Appeal Decision

Appeal Ref: APP/T2350/D/23/3319209

52A Lowergate, Clitheroe, Lancashire, BB7 1AD

SHEET: EXISTING AND  
PROPOSED  
ELEVATIONS

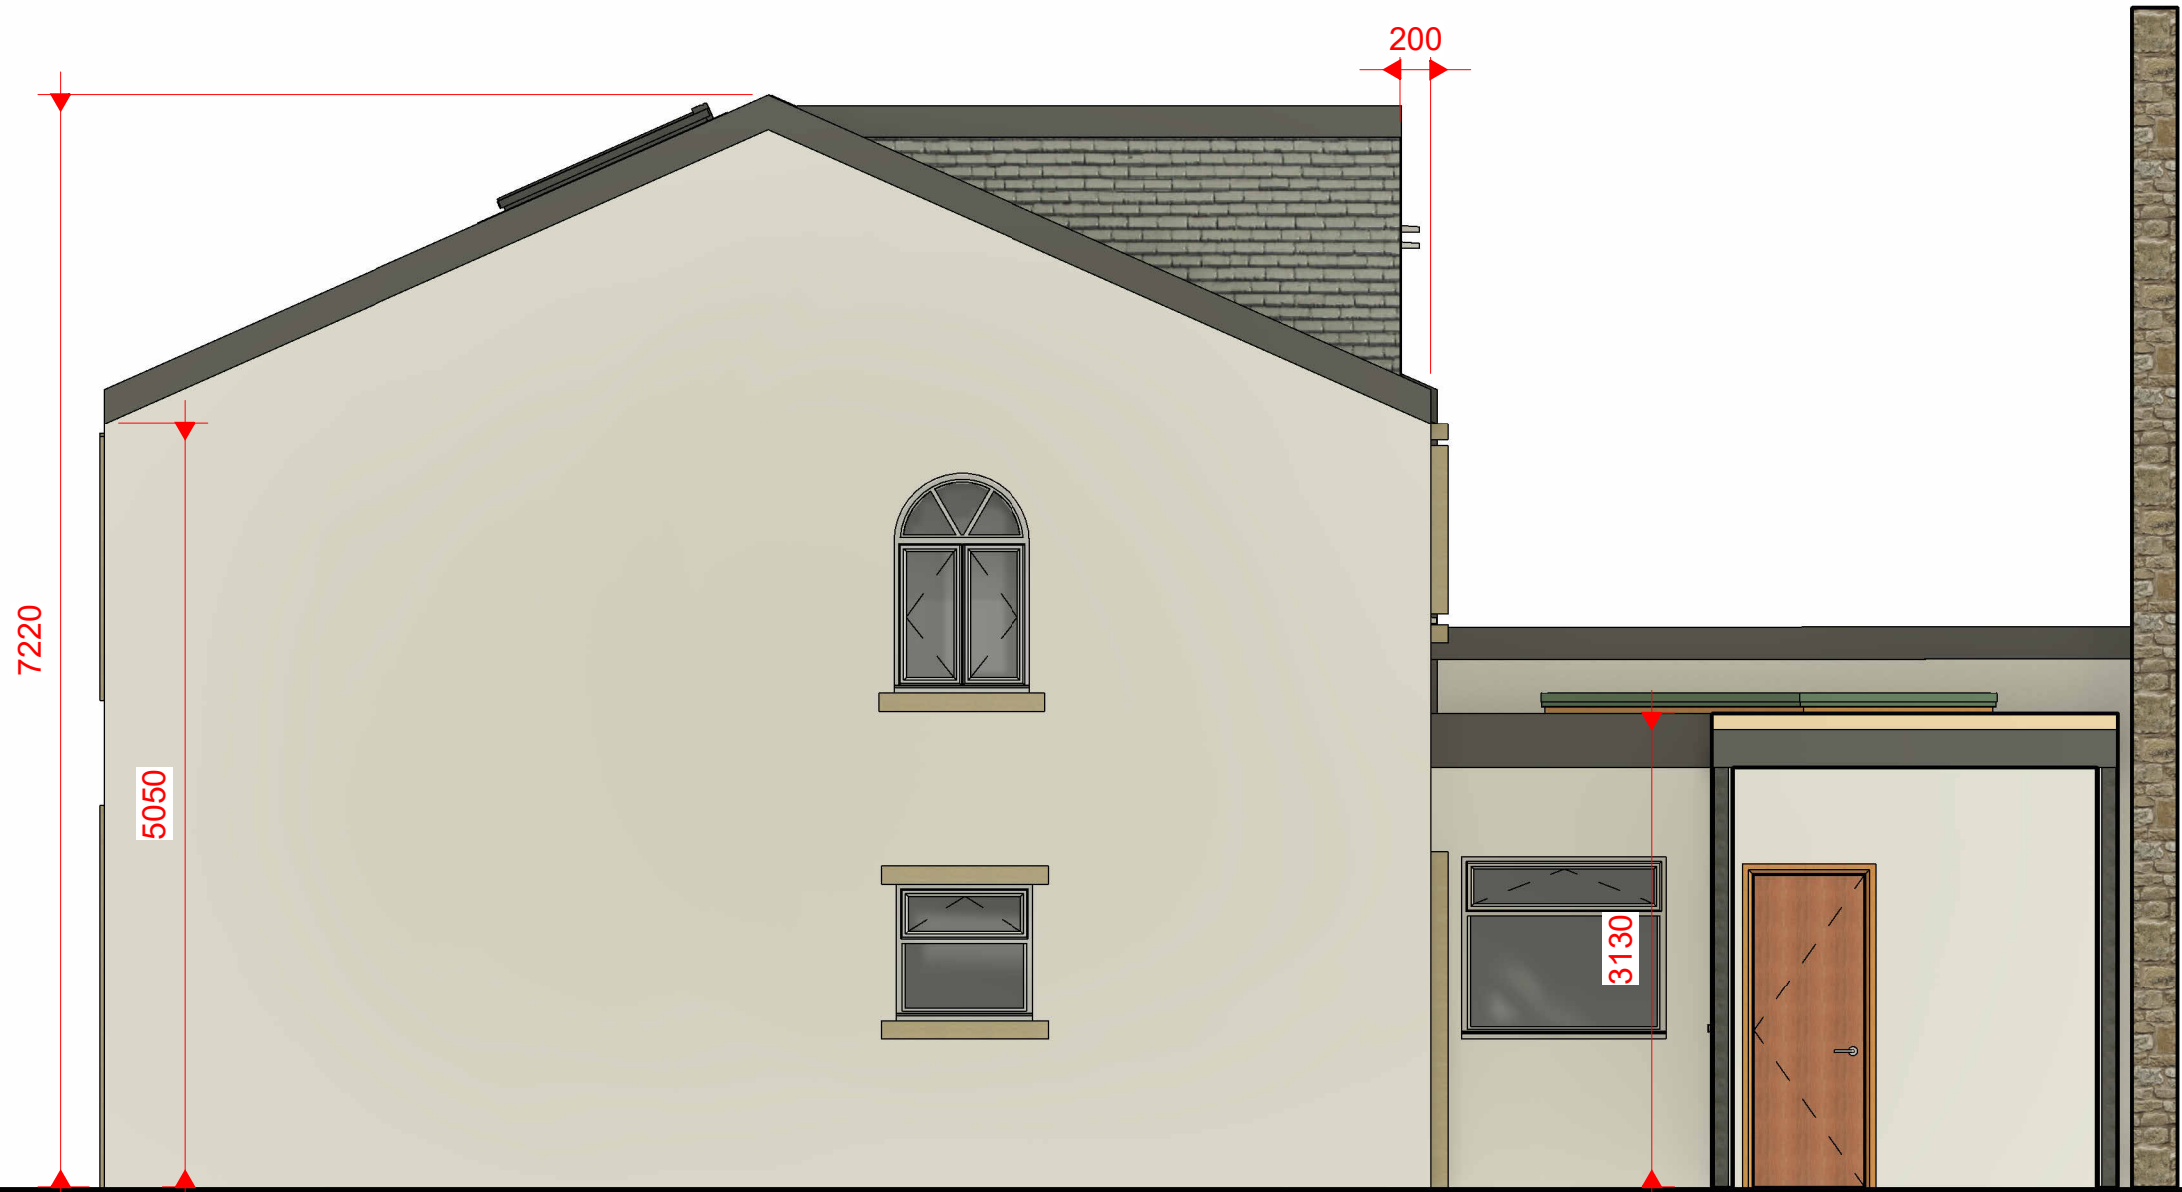
10. By contrast, the introduction of a dormer extension would be a significant and dominant alteration to the property that would occupy the majority of the rear roof slope. Such a bulky addition would result in the introduction of a overly dominant feature that would unbalance the roof line of these semi-detached properties to the detriment of the character and appearance of the host building.

11. The visual impact of the dormer is minimised by virtue of its position to the rear elevation, and siting above the eaves and beneath the ridge line. I also acknowledge that the rear roof slope is not prominently sited. However, where it is visible, particularly from the steps from the car park leading to the town centre, it would appear as an incongruous feature within the surrounding roofscape.

13. Therefore, by virtue of its scale, mass and proportions, the proposed development would not reflect the surrounding built form found within this part of the conservation area. Accordingly, it would detract from the overall appearance of the CCA.
